Application no: 3/2019/0558

Address: Holden Clough Nursery
Proposal: Proposed Car Park Extension

Holden Clough Nursery -
Proposed Overflow Car
Park & Growing Area
Scale: 1:500 @ A3

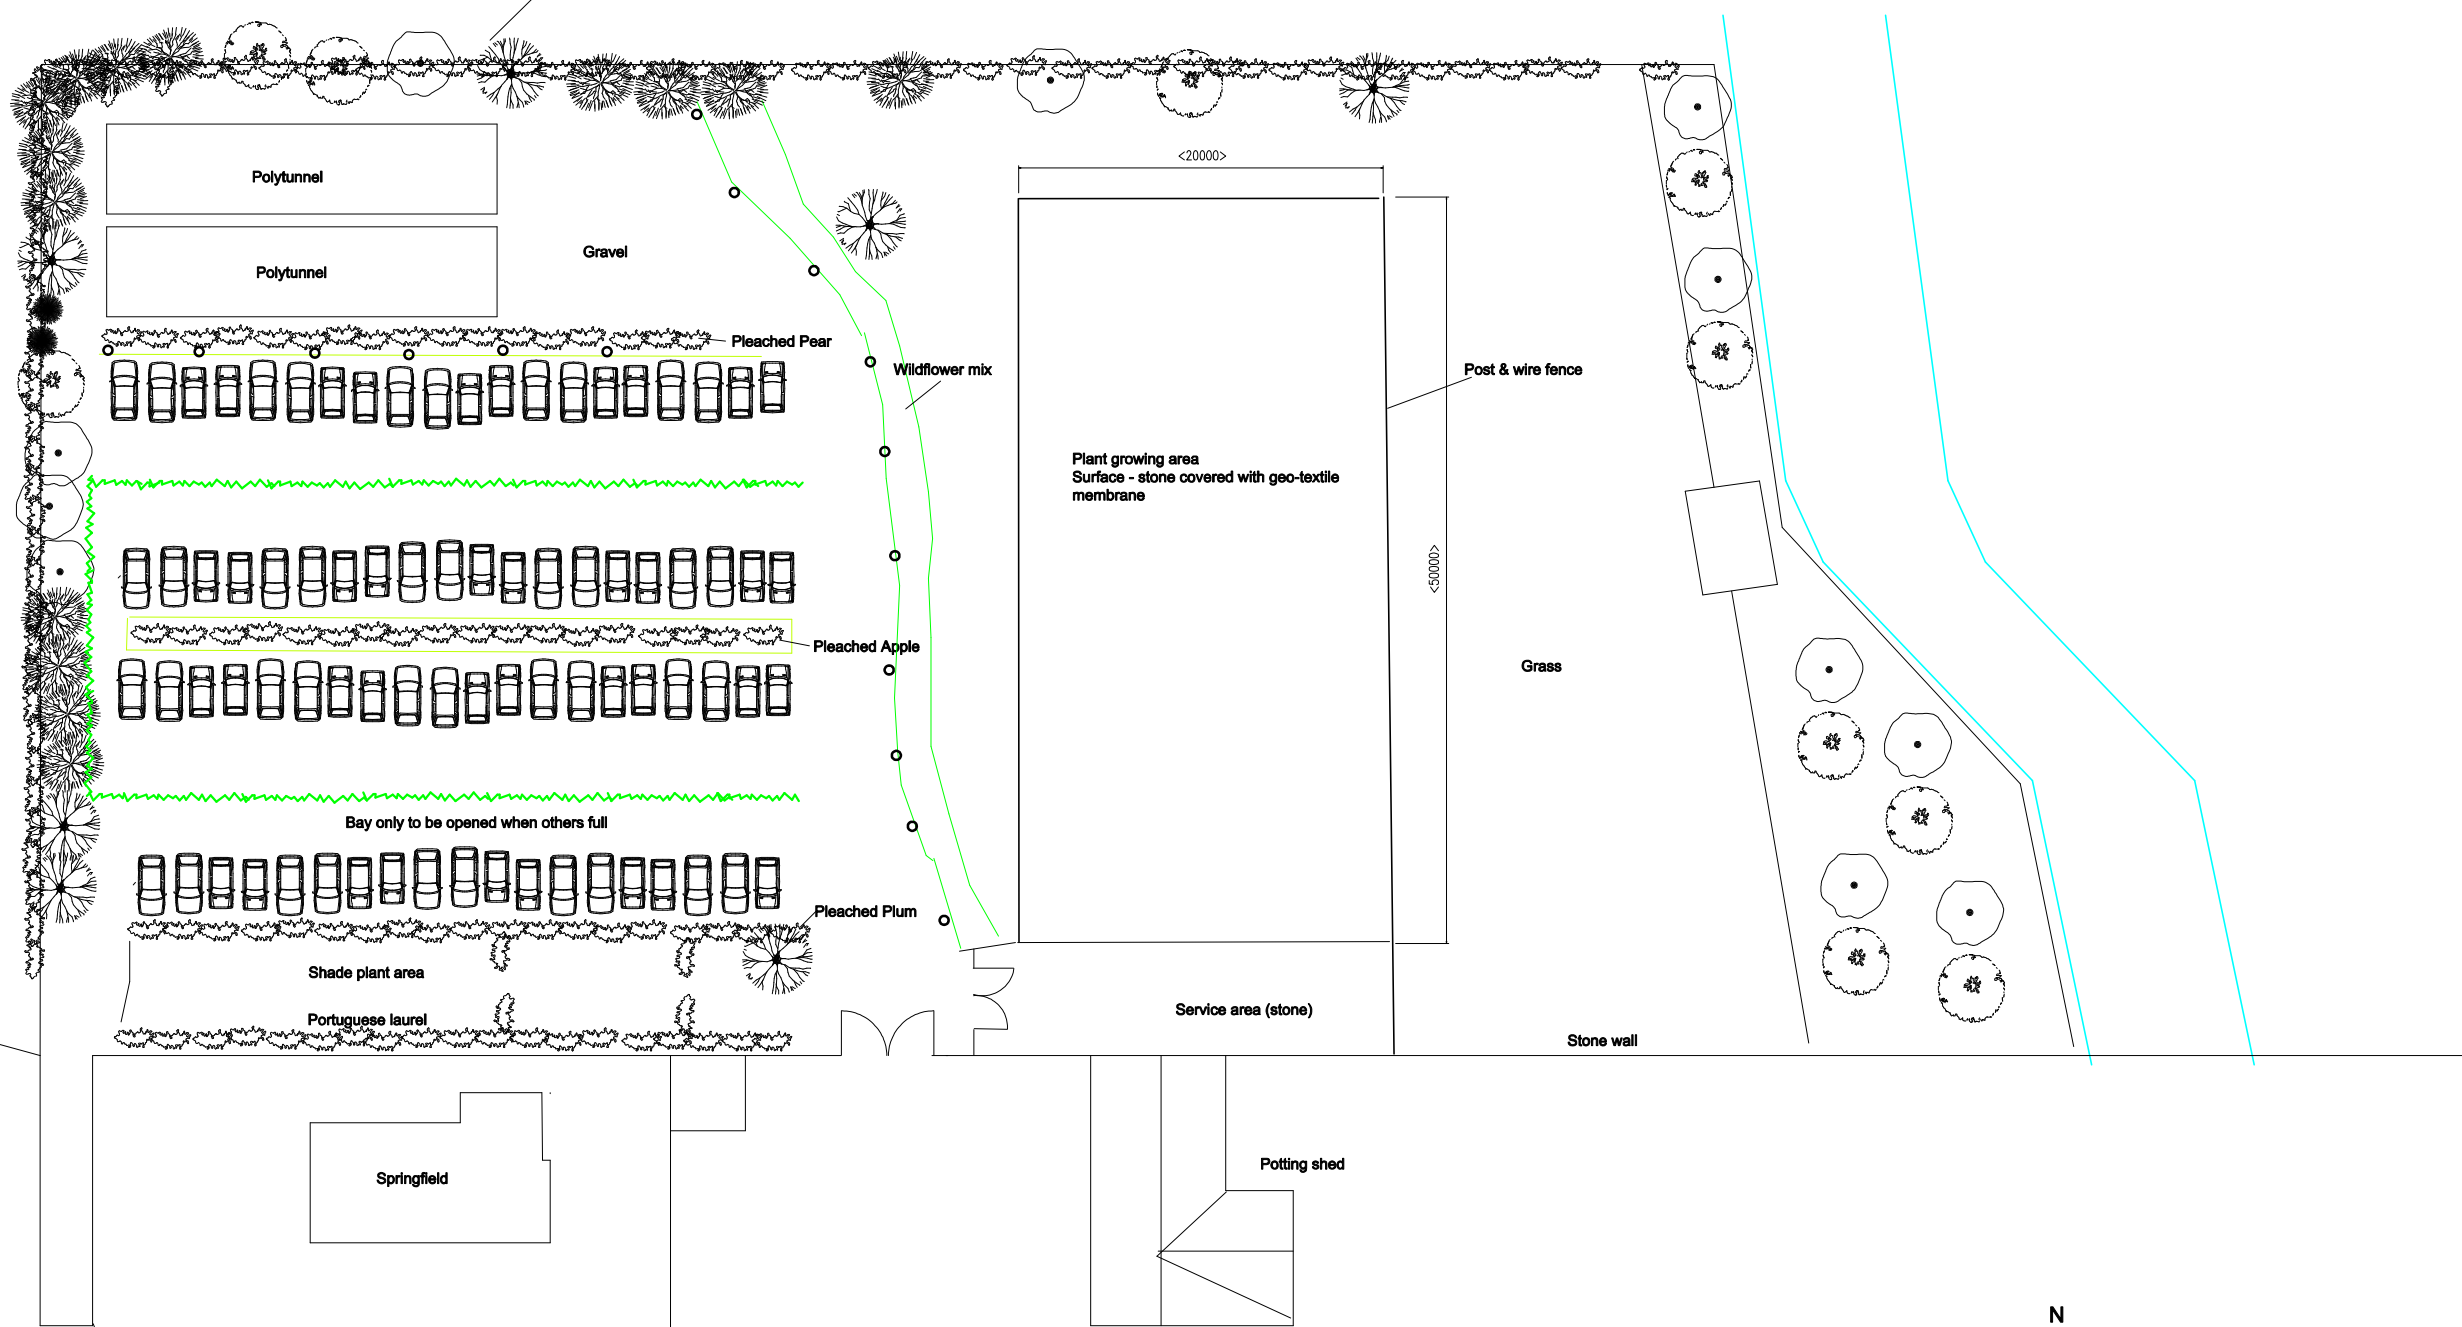
The extended car park may not be visible from the road and visitors may resort to parking on the carriageway. . In an effort to avoid this there should be prominent signage to advise that additional parking facilities are available to the rear. It would be possible to remove parking along Barrett Hill Brow by implementing waiting restrictions, however these would be seen as being detrimental to the visual aesthetic and in practical terms, unlikely to be enforced. I would therefore suggest

that discreet signage is erected along the Barrett Hill Brow site frontage to discourage parking and the signage reinforced at the customer entrance point.

1 Before the commencement of any development on site the applicant shall submit a scheme for signage with9in the site to advise of the presence of the car park and to discourage parking on Barrett Hill Brow. The approved sign schedule shall be erected prior to the first use of the car park and maintained in perpetuity thereafter.
